STATE OF WASHINGTON  
DEPARTMENT OF ECOLOGY  
1250 W Alder St • Union Gap, WA 98903-0009 • (509) 575-2490

May 18, 2017

Re: PD-16-00001 and LP-17-00004

Thank you for the opportunity to comment during the optional determination of nonsignificance process for the rezone of 4.47 ac parcel to a Planned Unit Development and divide the 4.47 acres into 34 lots. This project is proposed by MDJ Contractors, LLC. We have reviewed the documents and have the following comments.

SHEET CONTENTS
SITE PLAN

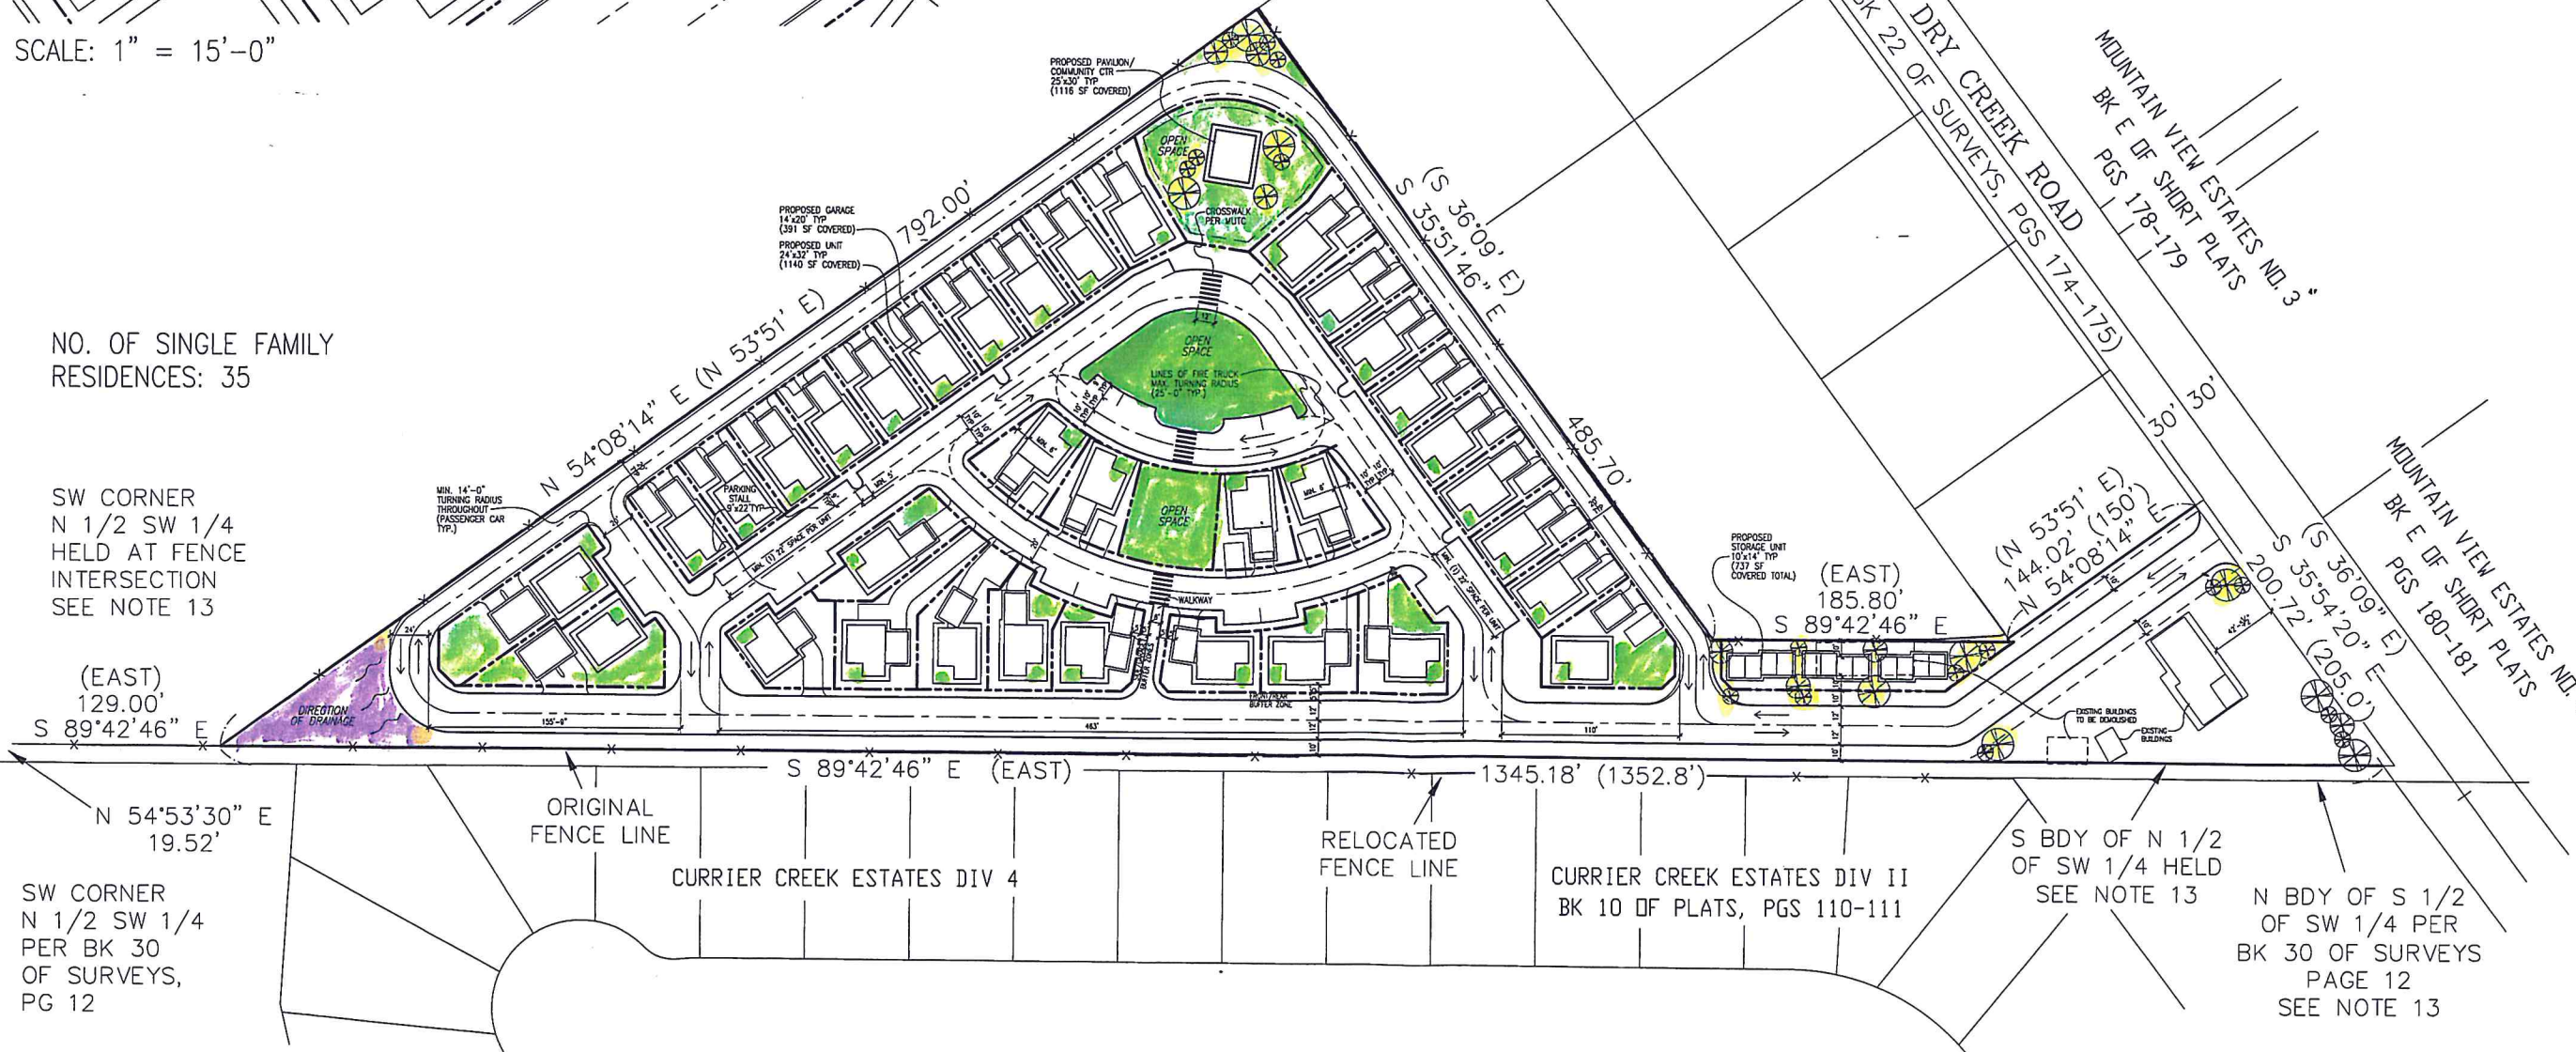
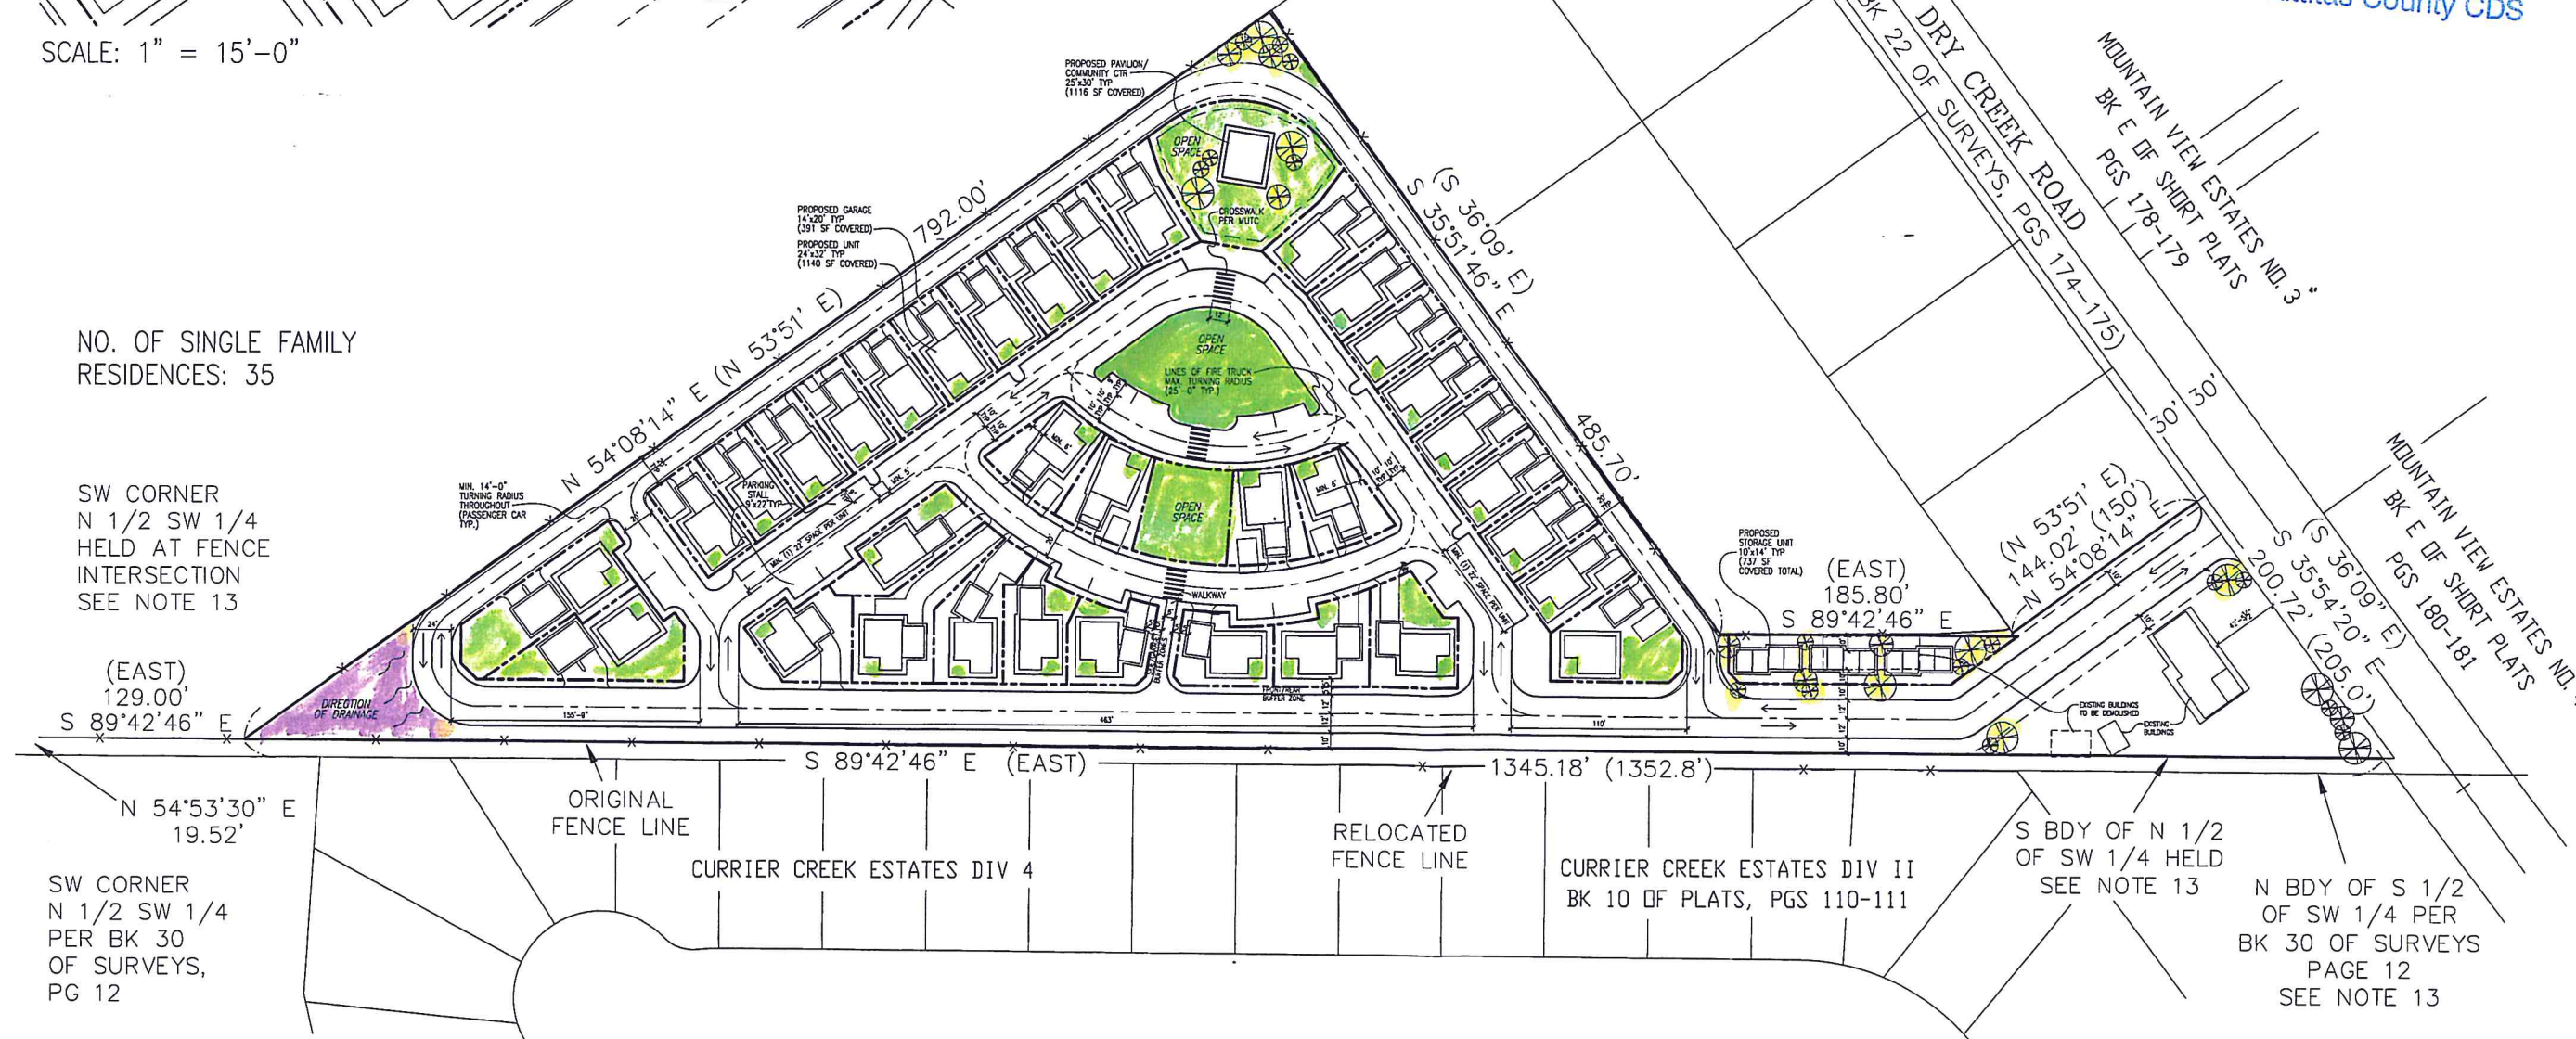
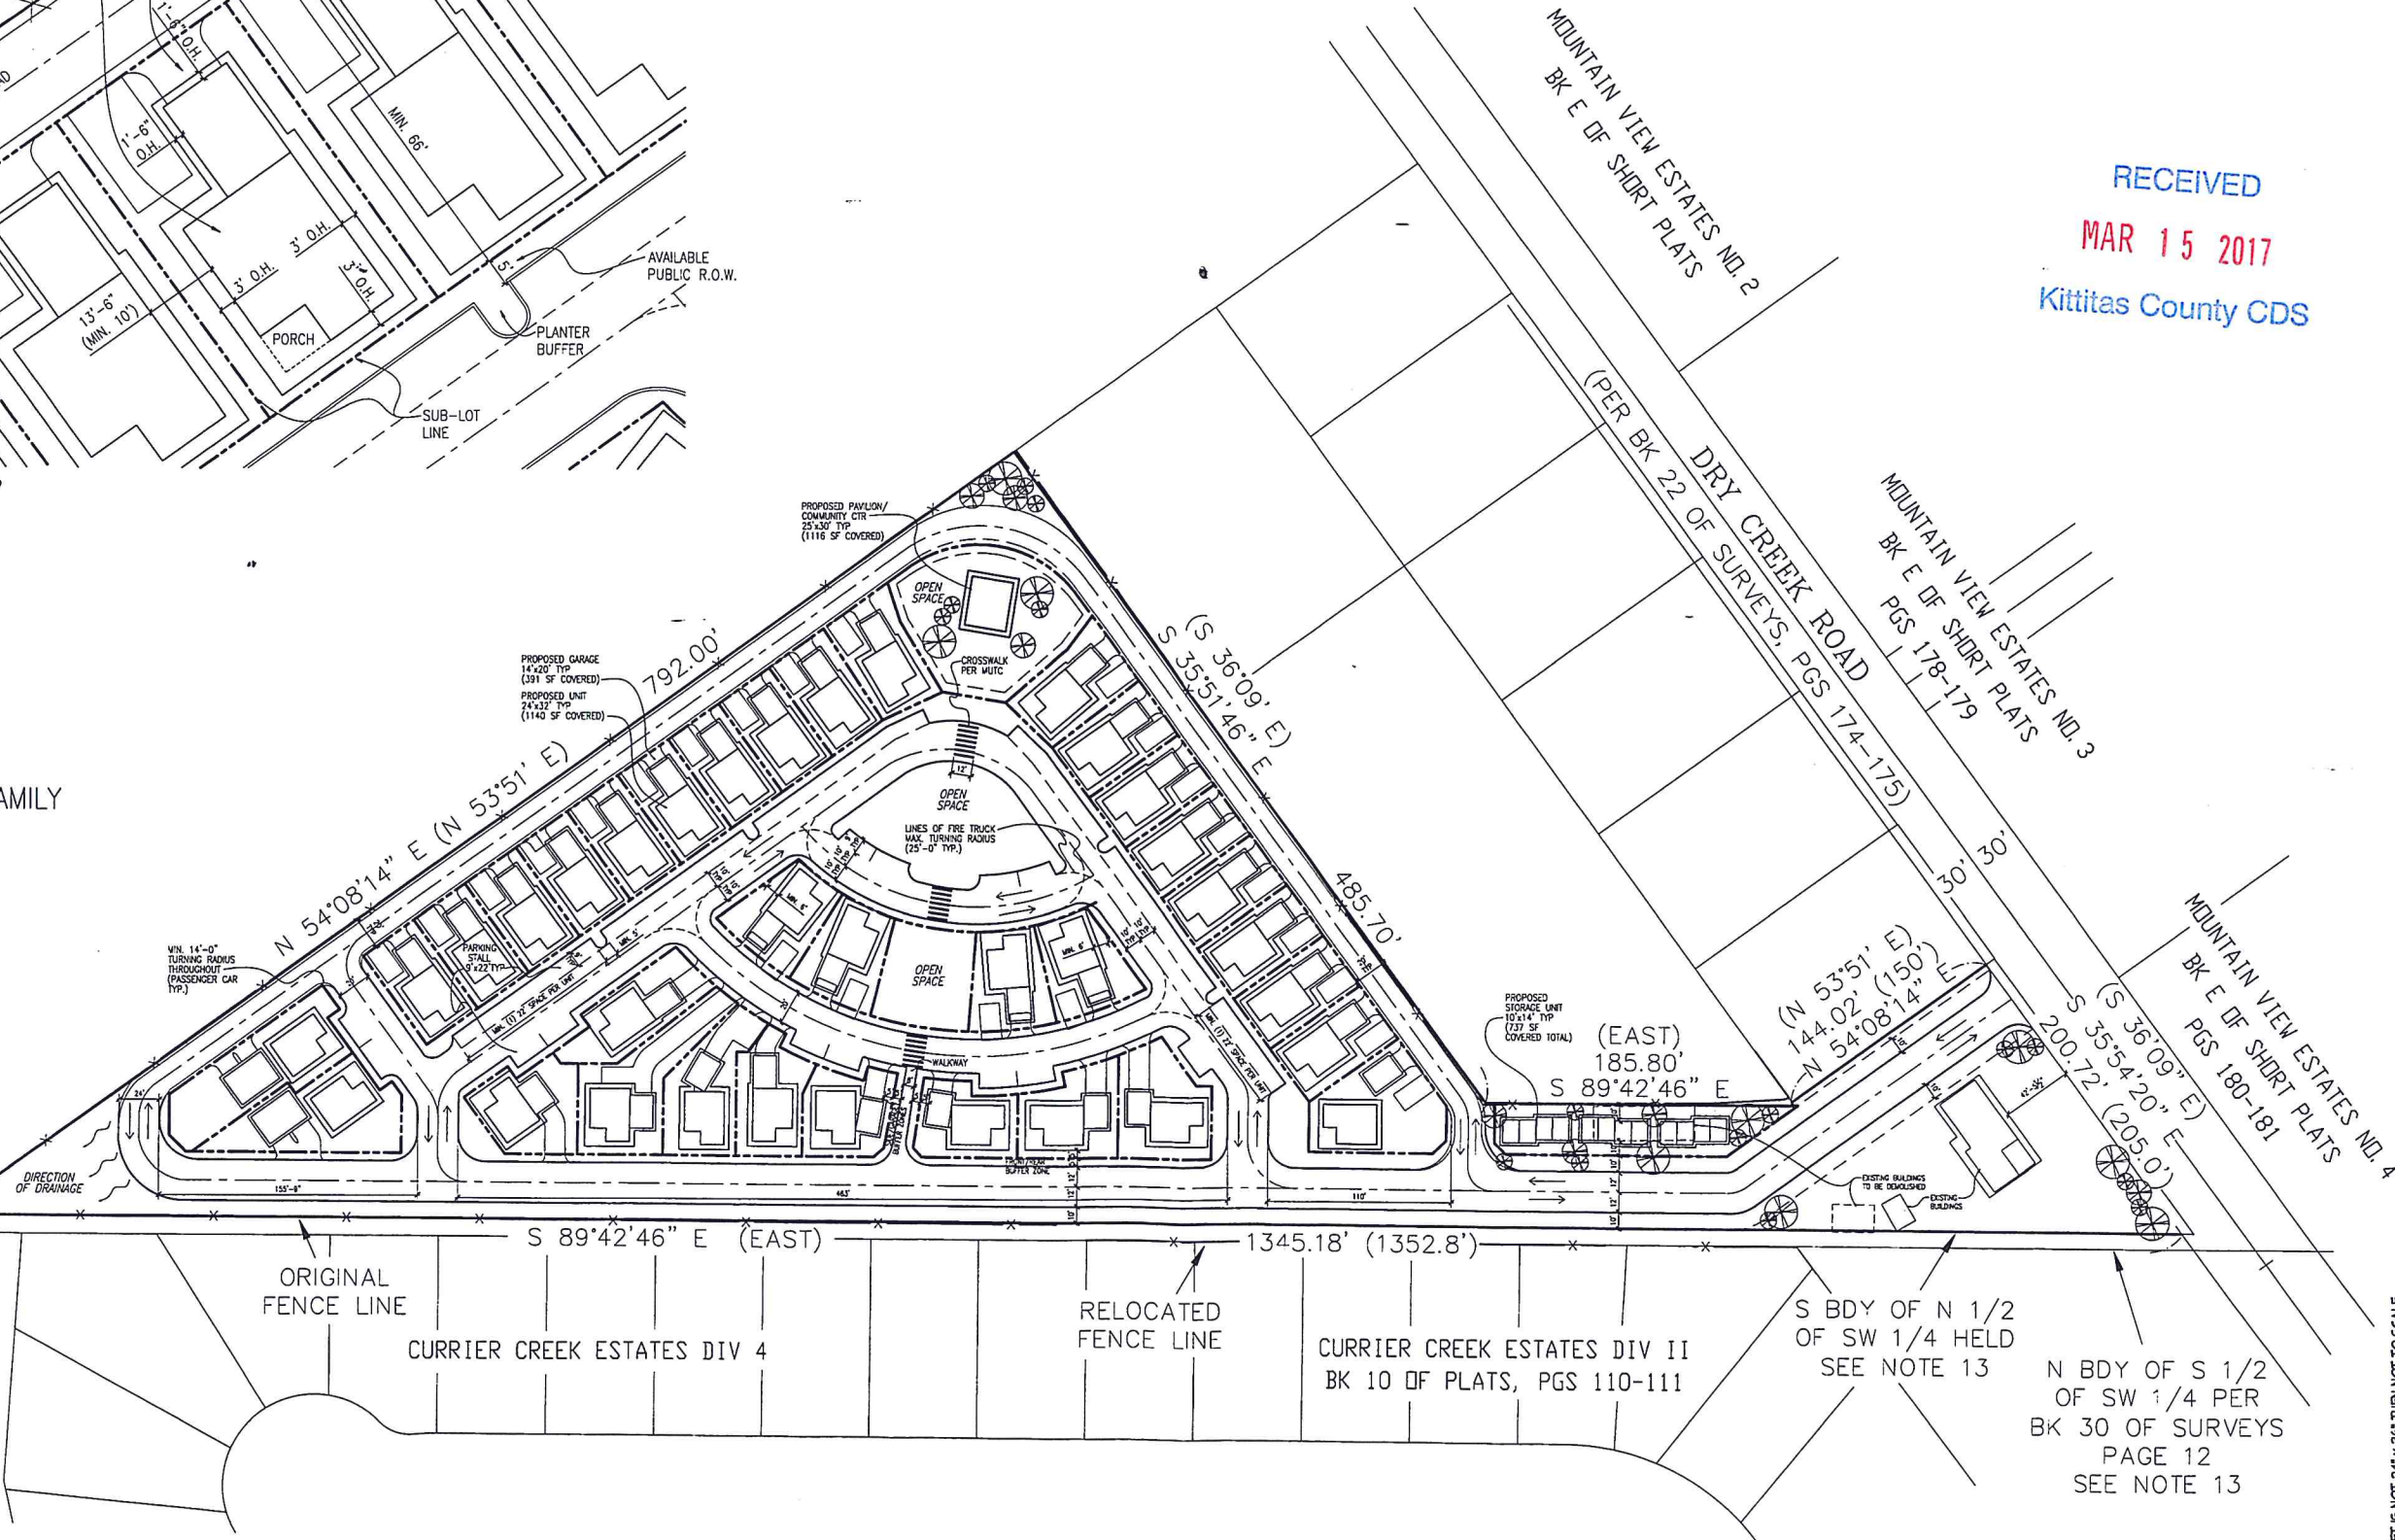
National wetland inventory maps provided at the County website show that this subdivision area is almost 100 percent wetland, but no other mention of the issue is made anywhere else in the other County documents. Was a wetland delineation completed for the site? A wetland delineation should be prepared for the site and available for public review and comment as part of the SEPA process.

Wetlands provide important flood attenuation and water quality treatment and any wetland areas on or adjacent to the site should be protected under applicable local, state and county wetland regulations. Since the project area is subject to natural flooding patterns (see aerial photo below provided to Ecology by WA Dept. of Fish and Wildlife) and because of the project area's proximity to Currier Creek, any wetlands that are found to be present on site would be subject to GMA regulations, and should be protected or mitigated in accordance with Best Available Science.

Adequate stormwater and flood retention capability should be set aside on site. This is needed in order to protect adjacent wetlands and the water quality of Currier Creek and other downstream waters.
